DELEGATED DECISION TO DETERMINE PLANNING APPLICATIONS

Reference No: 2021/62/90168/W

Site Address: 72, Wood Lane, Newsome, Huddersfield, HD4 6PT

Description: Raising of roof height, erection of extensions and alterations to roof and erection of front and rear dormers to create first floor accommodation and erection of rear extension

Front Elevation
1 : 100

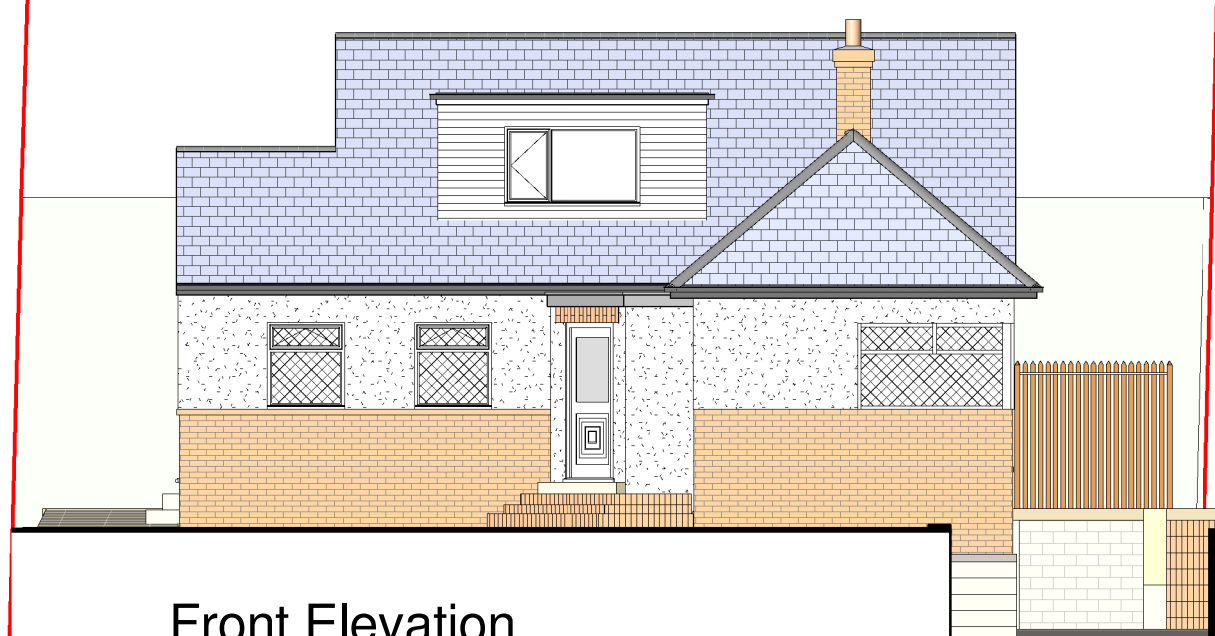
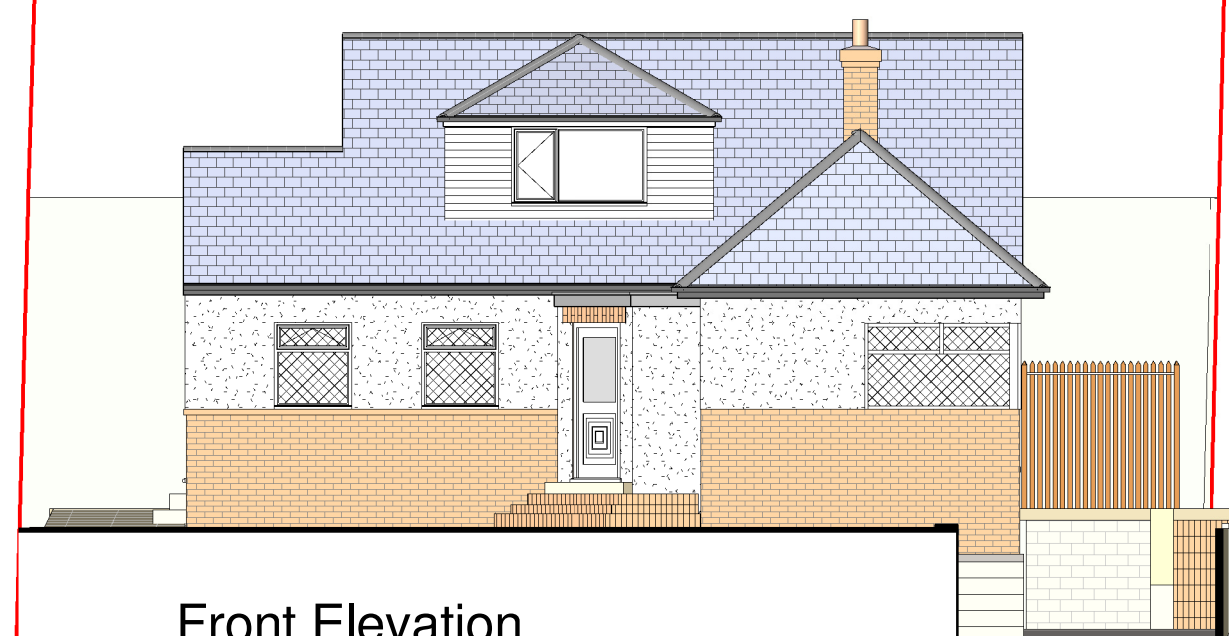
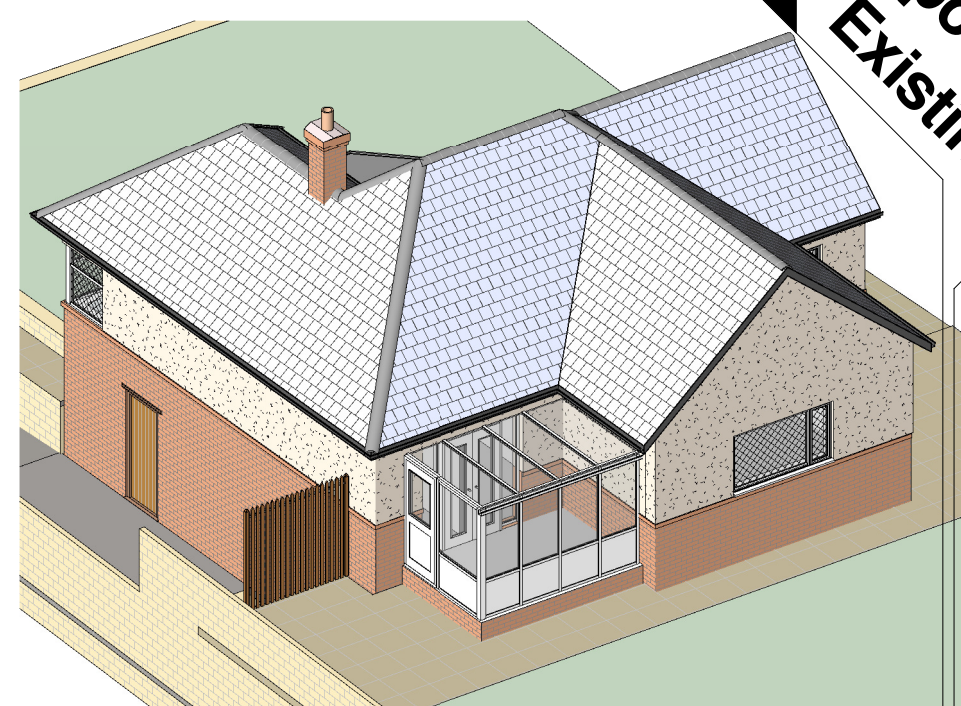
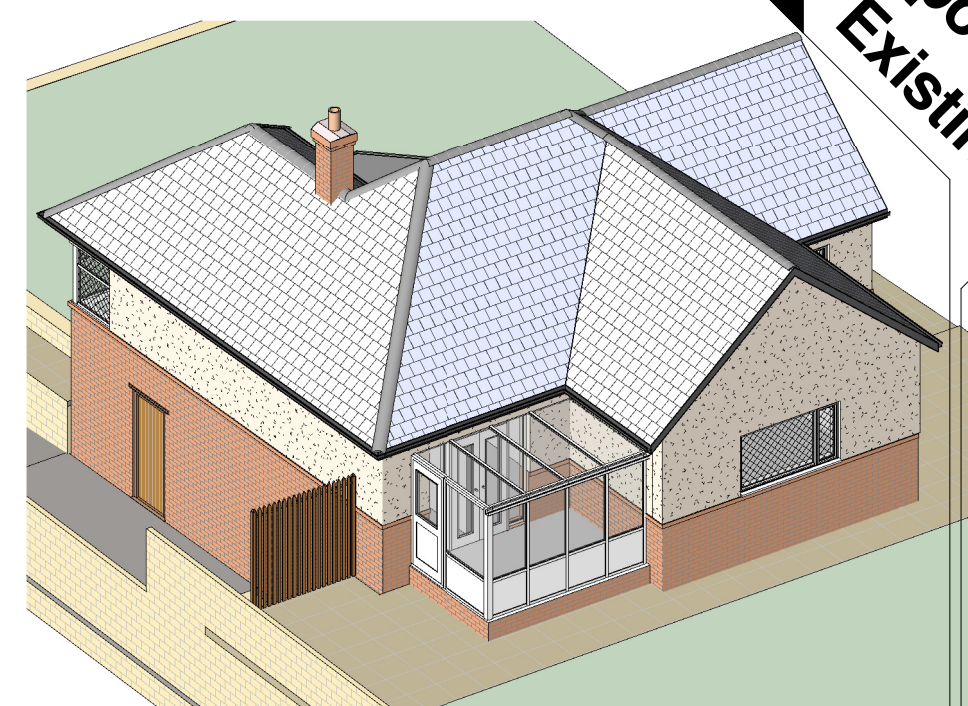
Throughout the course of the application, amended plans were sought to improve the design of the front dormer in terms of the visual amenity of the street scene and the previous flat roof designed dormer would now have a hipped roof which is considered to be acceptable.

Pursuant to article 35 (2) of the Town and Country Planning (Development Management Procedure) Order 2015 and guidance in the National Planning Policy Framework, the Local Authority have, where possible, made a pre-application advice service available, complied with the Kirklees Development Management Charter 2015 and otherwise actively engaged with the applicant in dealing with the application. The Council's Ecologist was formally consulted and a request was made for a Bat Survey to be undertaken. As such, a Bat Surveyor was commissioned and a Bat Survey submitted on 15th April 2021. In addition, it was requested that an amendment was made to improve the design of the front elevation dormer extension given that there are no other dormers within the front elevation roof slopes within the street scene. An amended plan was received on 7th April 2021 which altered the design of the front dormer from being a flat roofed dormer to being a hipped roof dormer.
